Our ref: DOC20/443348

Notice of Exhibition of application for Powerhouse Parramatta – SSD 10416

Tim Smith OAM
Director Operations
Heritage NSW
Department of Premier and Cabinet
As Delegate of the Heritage Council of NSW
9 July 2020

Figure 6.3: Excavation Plan (Moreau Kusunoki/Genton, DA070, Rev. 1, 1.4.2020)

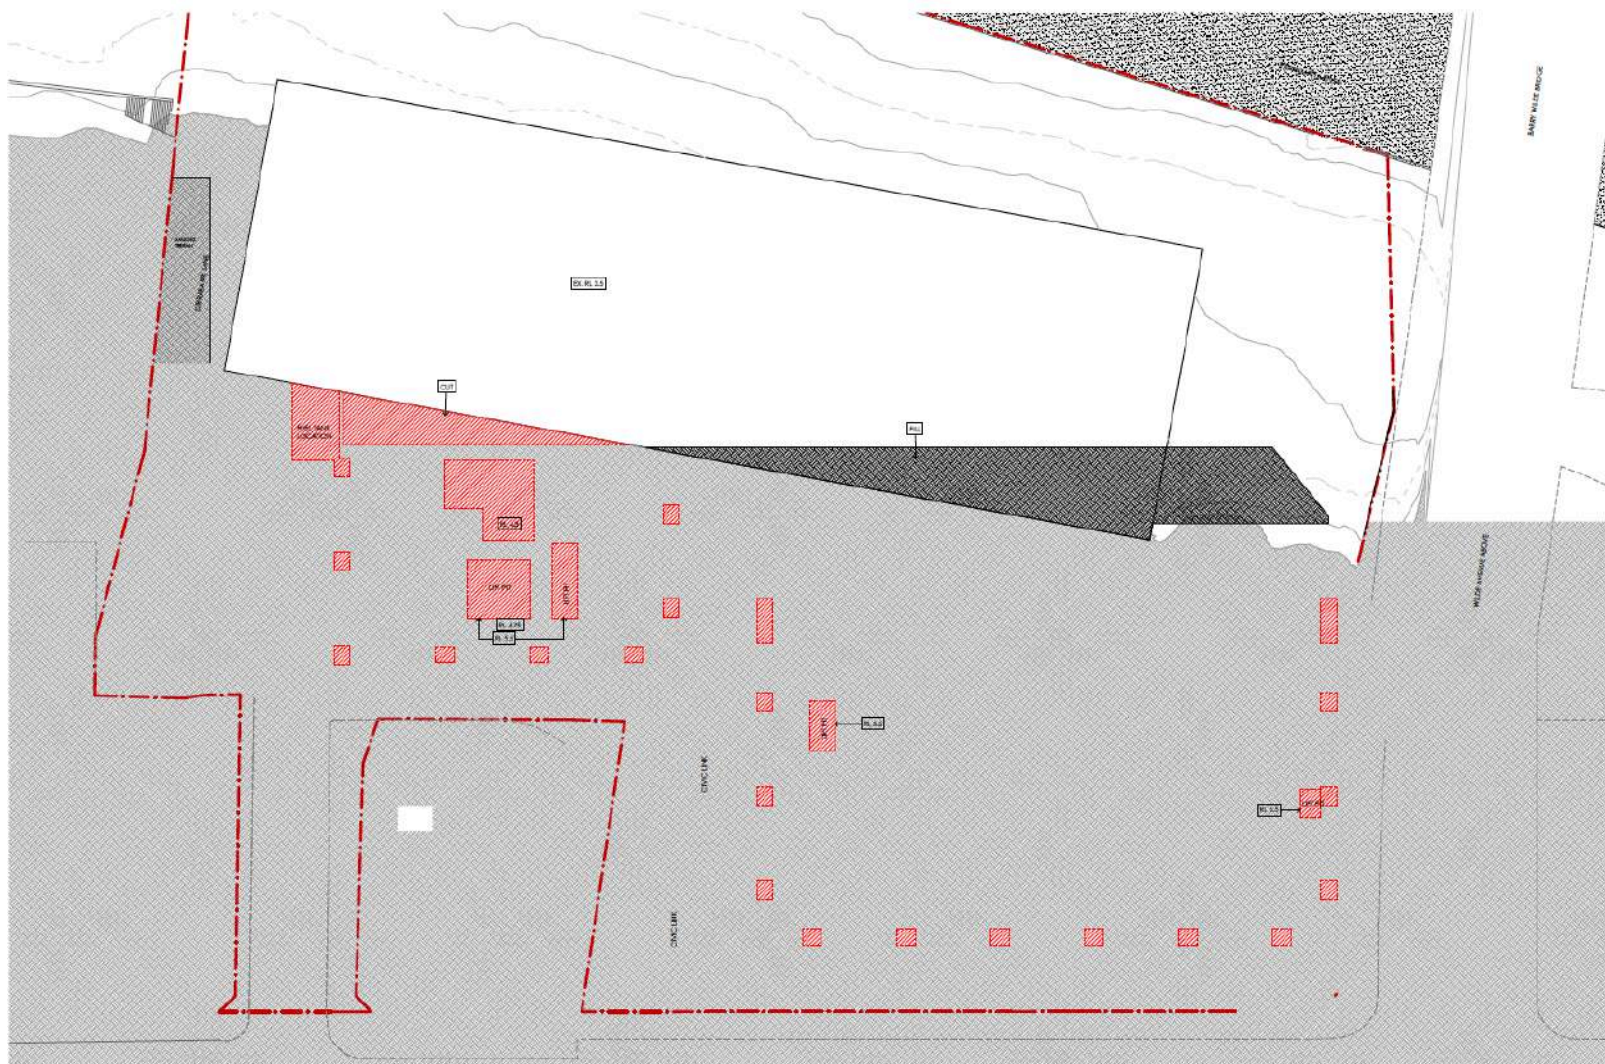
Curio Projects has assessed the development to require physical impacts to areas containing potential archaeology of both State and Local heritage significance. These include excavations for the support columns, service corridors and mature tree plantings. We note the statement by Curio Projects that if possible, elements of the construction should be redesigned to avoid impacts on archaeology. The Heritage Council supports this general approach.
